Intermodal Logistics Centre at Enfield

**Modification Application No. 6
ECI Detailed Design Adjustments
and Subdivision**

Response to Submissions

July 2012

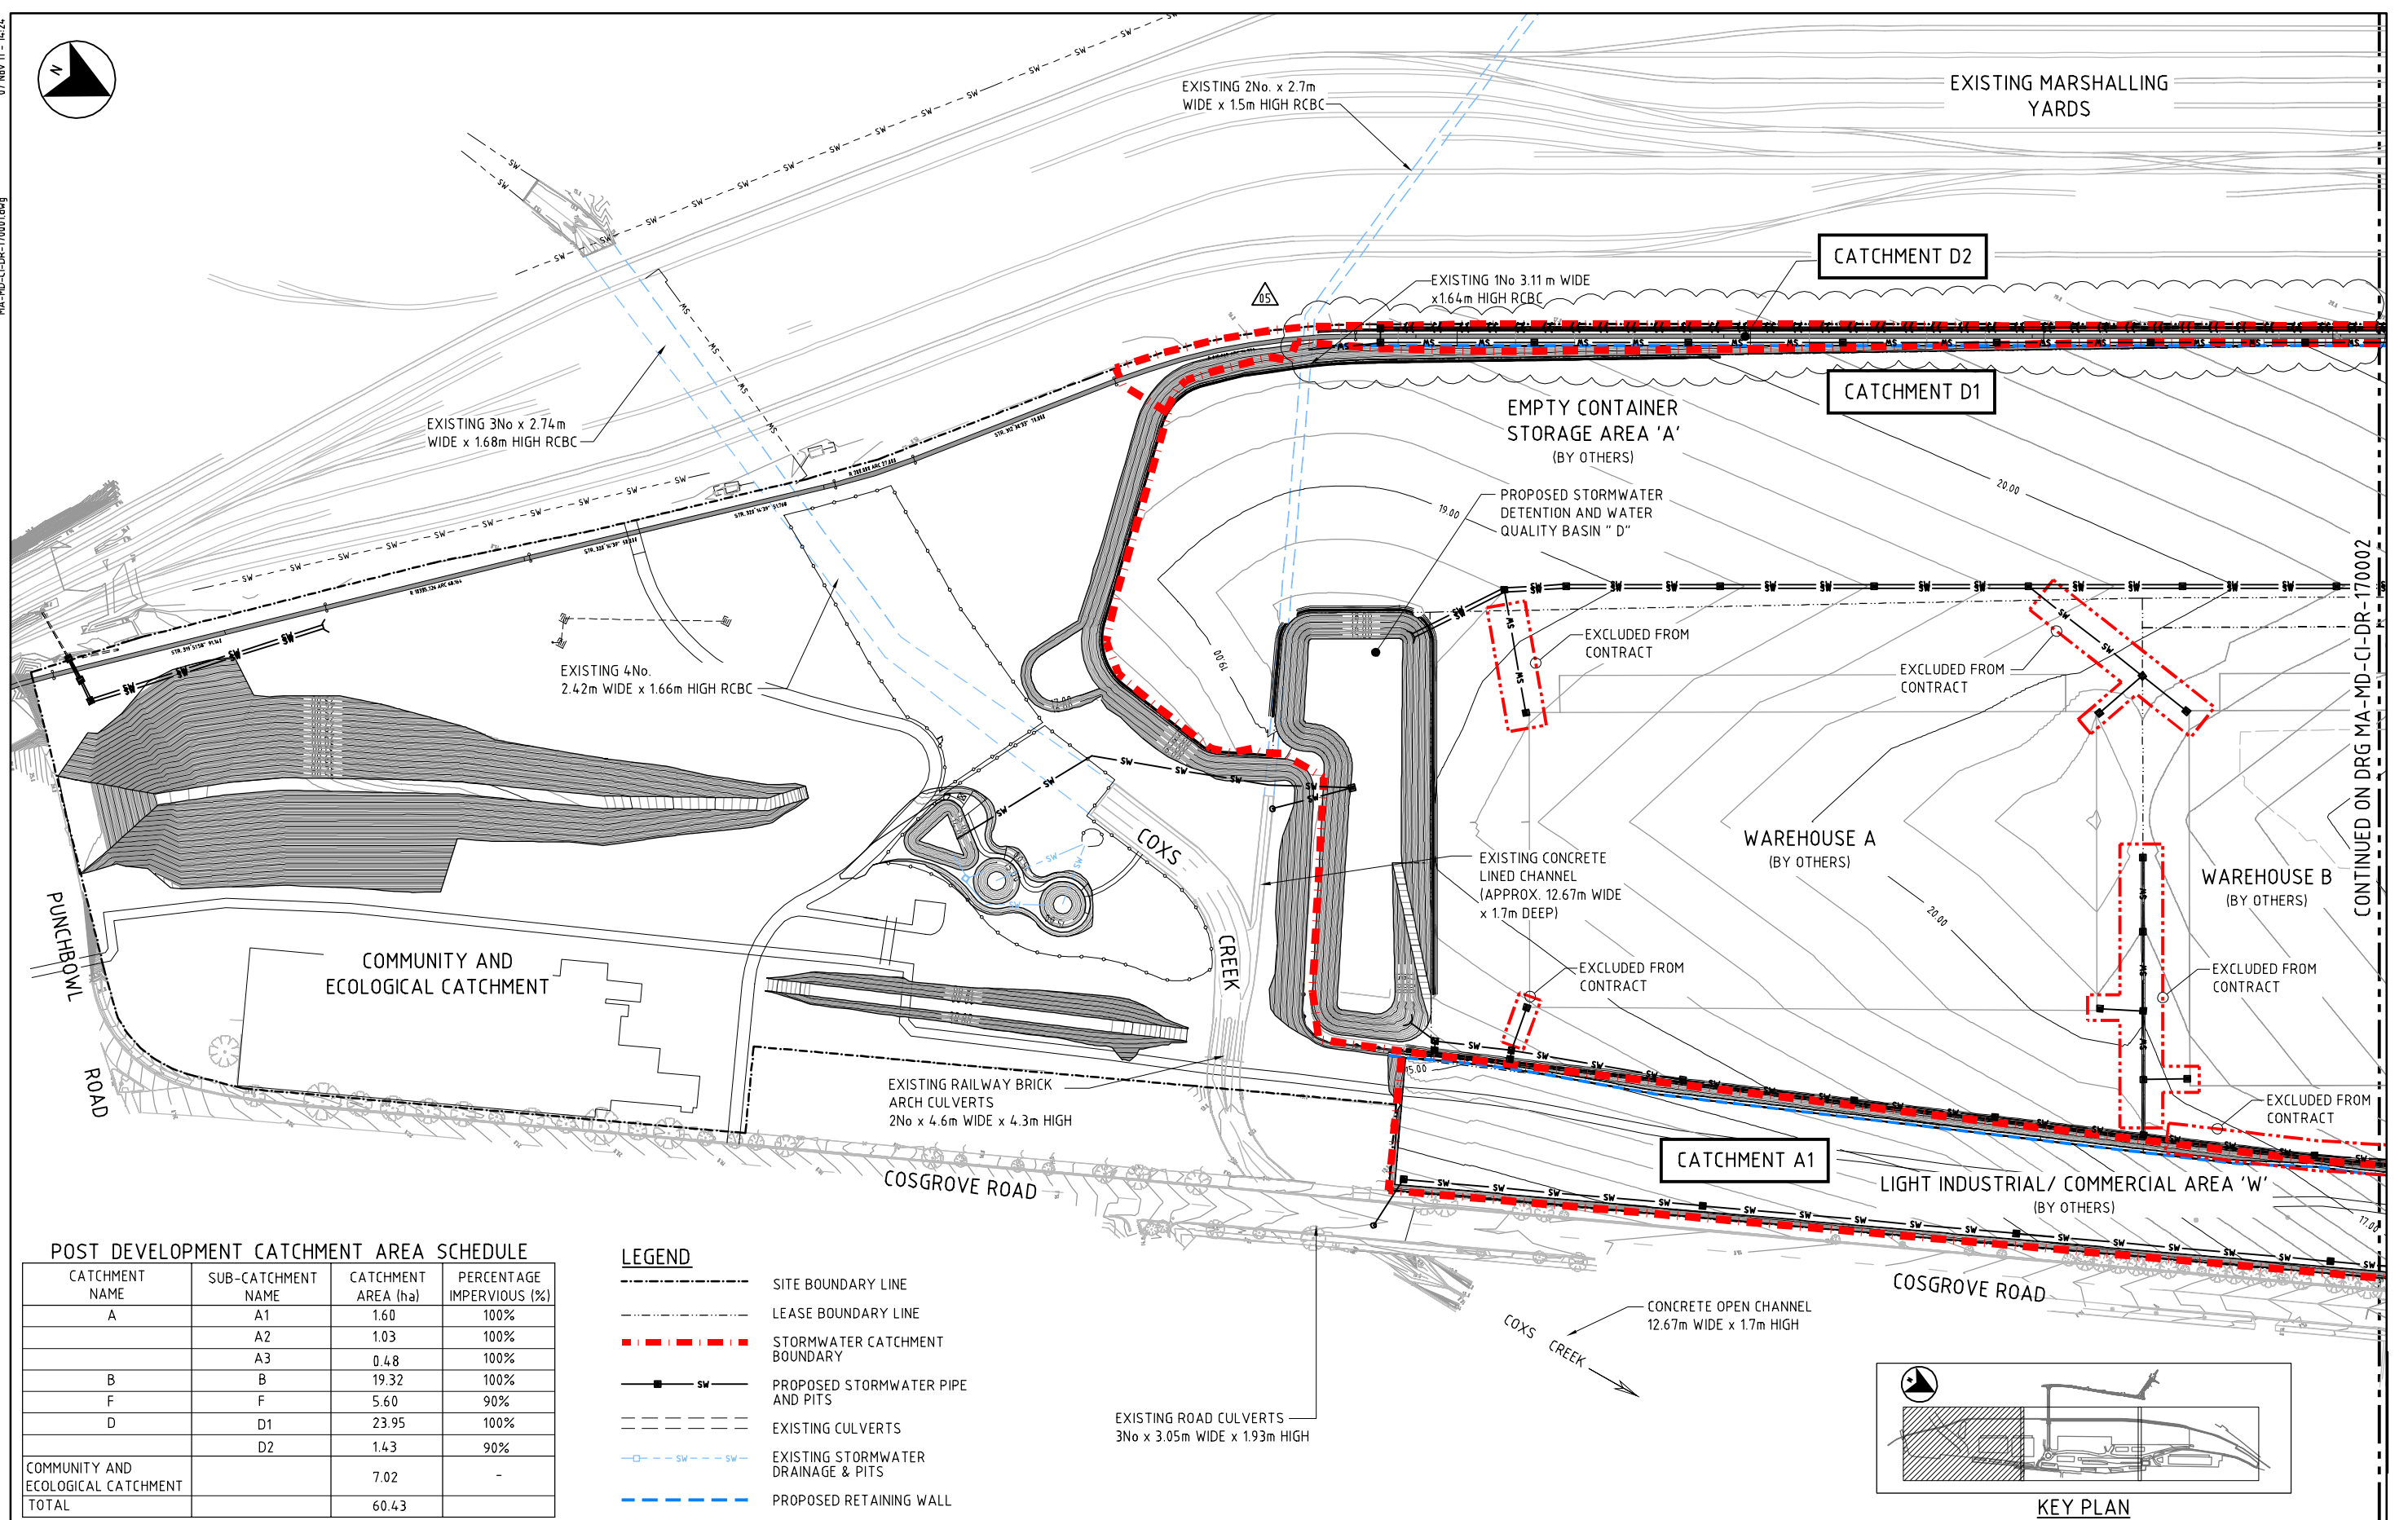
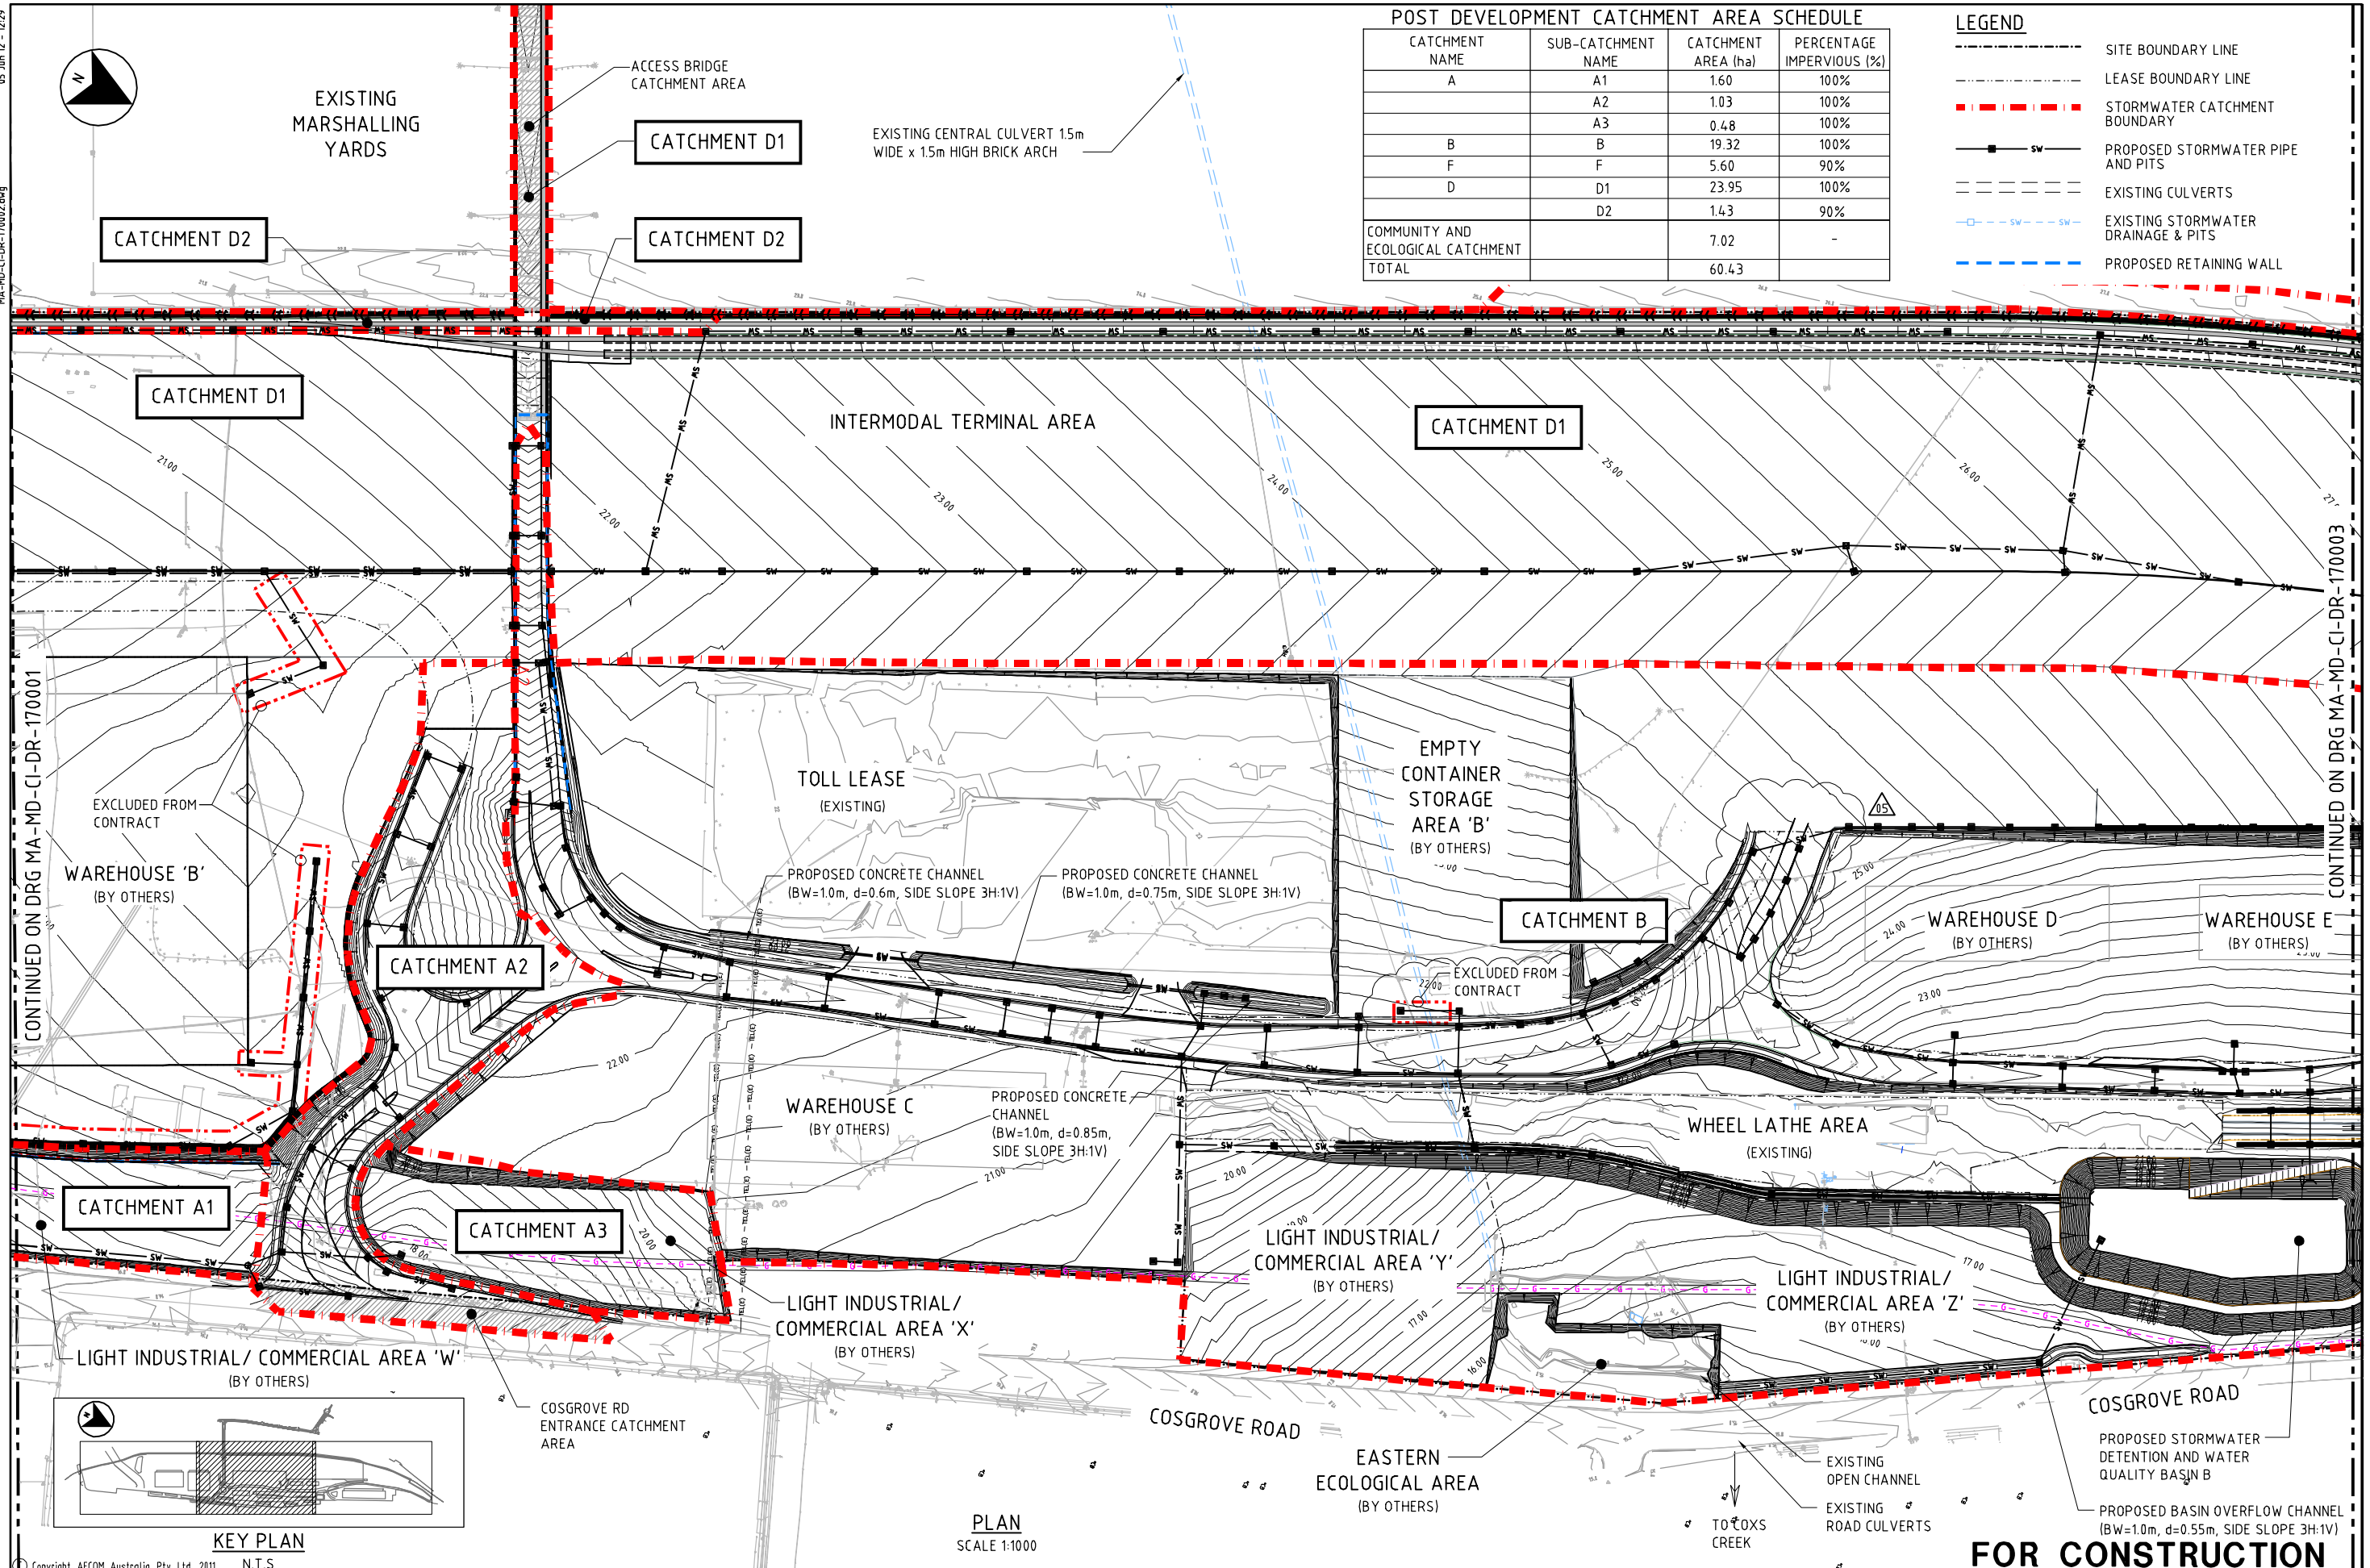
SMC's submission includes issues relating to the reconfiguration of internal site sub-catchments and the area of impervious surface of the site which will be diverted to Coxs Creek.

The general re-configuration of existing sub-catchments as described in the Environmental Assessment (EA) (SKM, 2005) and Preferred Project Report (PPR) (SKM, 2006) was initially approved in the 2007 Project Approval. Additional minor re-configuration of the catchments was approved in Modification 4. Modification 6 decreases the area draining to Basin D, which discharges to Coxs Creek, and increases the area draining to Basin B, which discharges via the "central drain" to Strathfield Council's stormwater system in Cosgrove Road from the arrangement proposed in Modification 4. The pre- and post-development catchment areas are provided in Table 2.2. Drawings showing the catchments draining to each basin are provided in Appendix C.

Table 2.2 also provides the pre- and post-development basin discharges. It can be seen that the reconfiguration of the catchment areas does not impact on the ability of the detention basin system to reduce the post-development flows to less than the pre-development flows.

Figure 3 of Modification 6 (refer Figure 1 of this Response to Submissions Report) show that runoff from the site sub-catchments are directed to Detention Basins B, C or D for both flow attenuation and water quality treatment. Drawings showing the catchments draining to each basin and the discharge points for each basin are provided in Appendix C.

PLAN OF PROPOSED SUBDIVISION OF THE
INTERMODAL LOGISTICS CENTRE
COSGROVE ROAD, ENFIELD

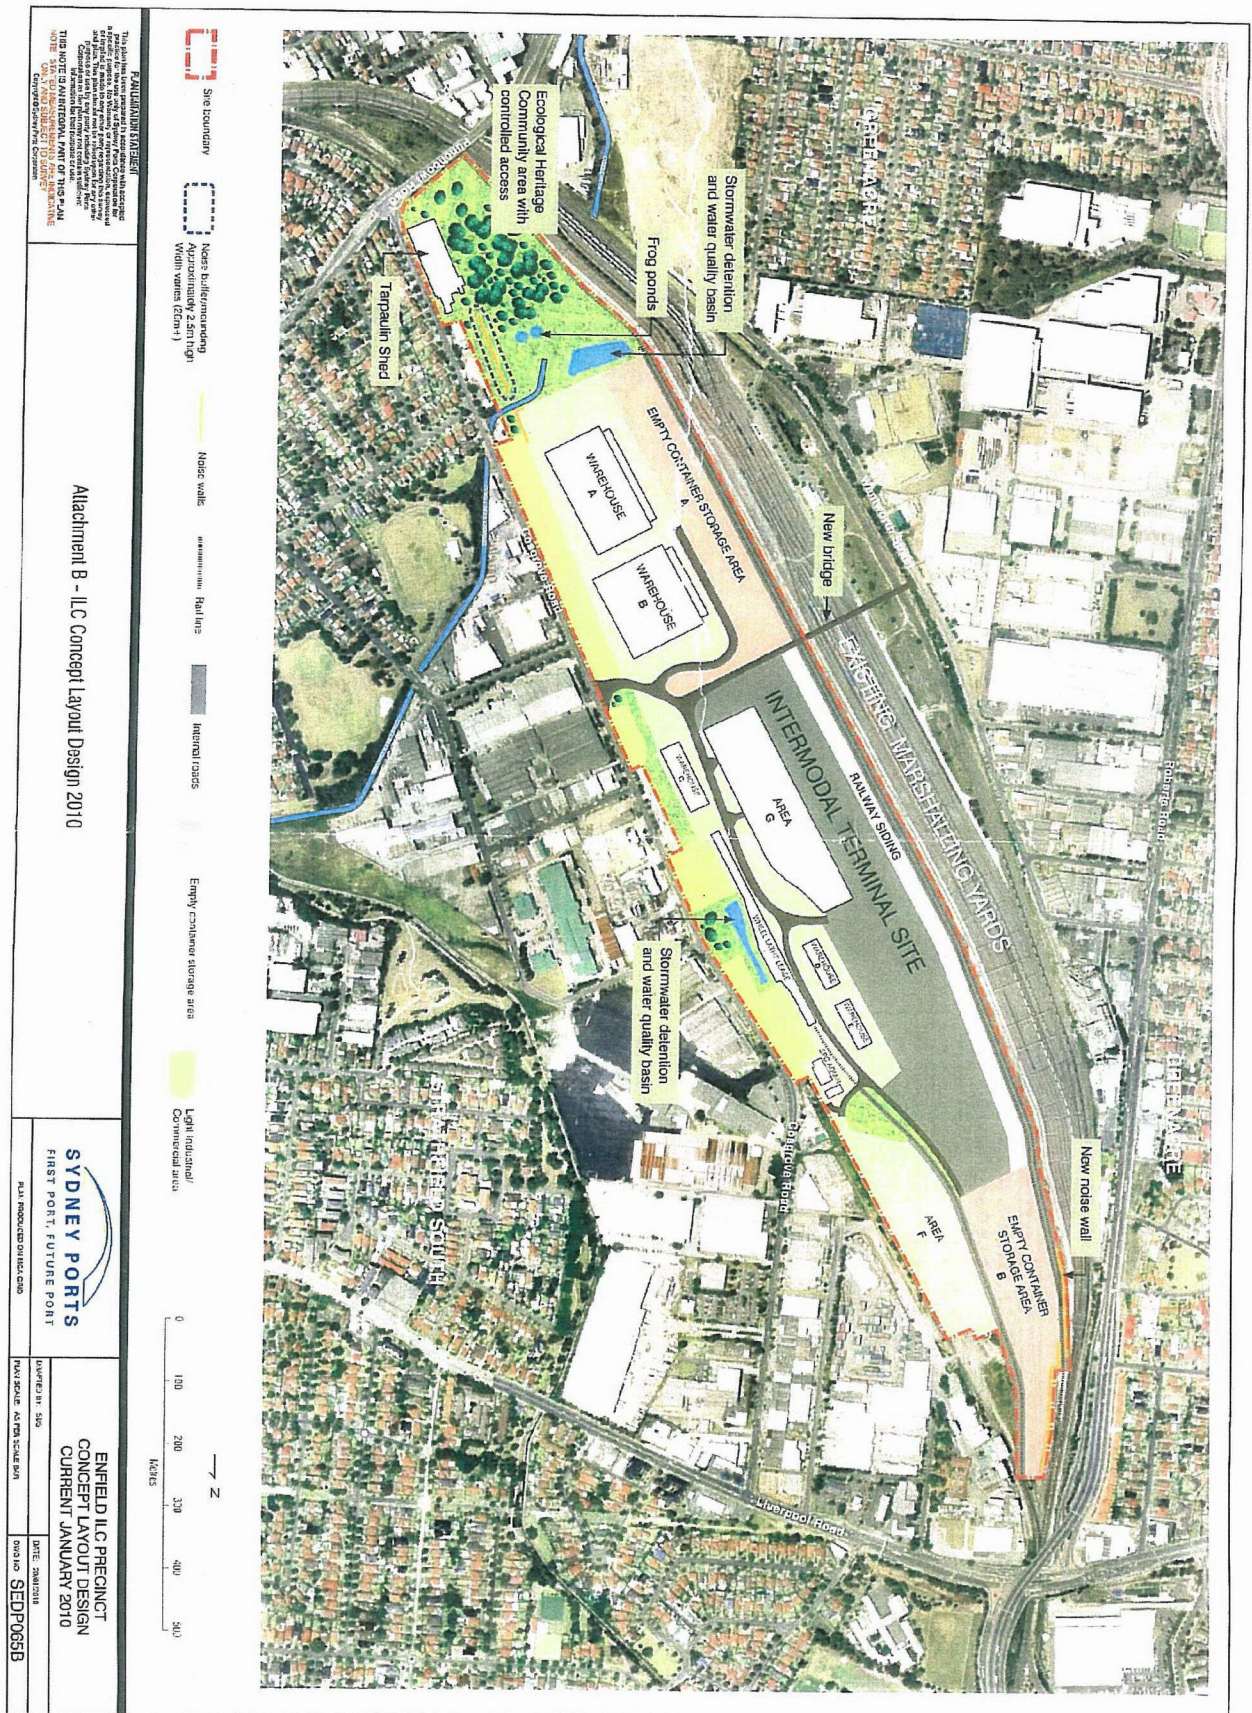
SMC commented that the proposed subdivision pattern conflicts with the intent of the original approval for the southern section of the site becoming a 'Community, Heritage and Ecological Area' and undermines its preservation as it creates potential opportunity for the sale or leasing. SMC also noted that the Strathfield Draft LEP 2011 includes the whole of the originally approved 'Ecological & Community and Heritage Area' as RE1 Public Recreation, with the main section of the ILC site zoned to General Industrial IN1. Currently the entire ILC site is zoned Special Uses B (Railways).

Sydney Ports does not believe that the proposed subdivision conflicts with the original approval for the southern area. Sydney Ports believes that the proposed subdivision pattern in conjunction with the proposed re-zoning as recommended by Sydney Ports' LEP submission would best support and protect the uses for the southern end of the ILC site proposed in the EA.

The subdivision pattern has been designed to allow the uses proposed in the EA. The proposed subdivision does not diminish the amount of land dedicated in the original approval for community, ecological and heritage purposes. Furthermore, the creation of Lot 19 enhances the potential for heritage related opportunities by defining the extent of the Tarpaulin Factory curtilage. This curtilage includes a rail access corridor previously known as the DELEC south sidings rail corridor adjacent to the shed (approximately 13 m wide) and the Qenos pipeline maintenance corridor (approximately 1 m wide).
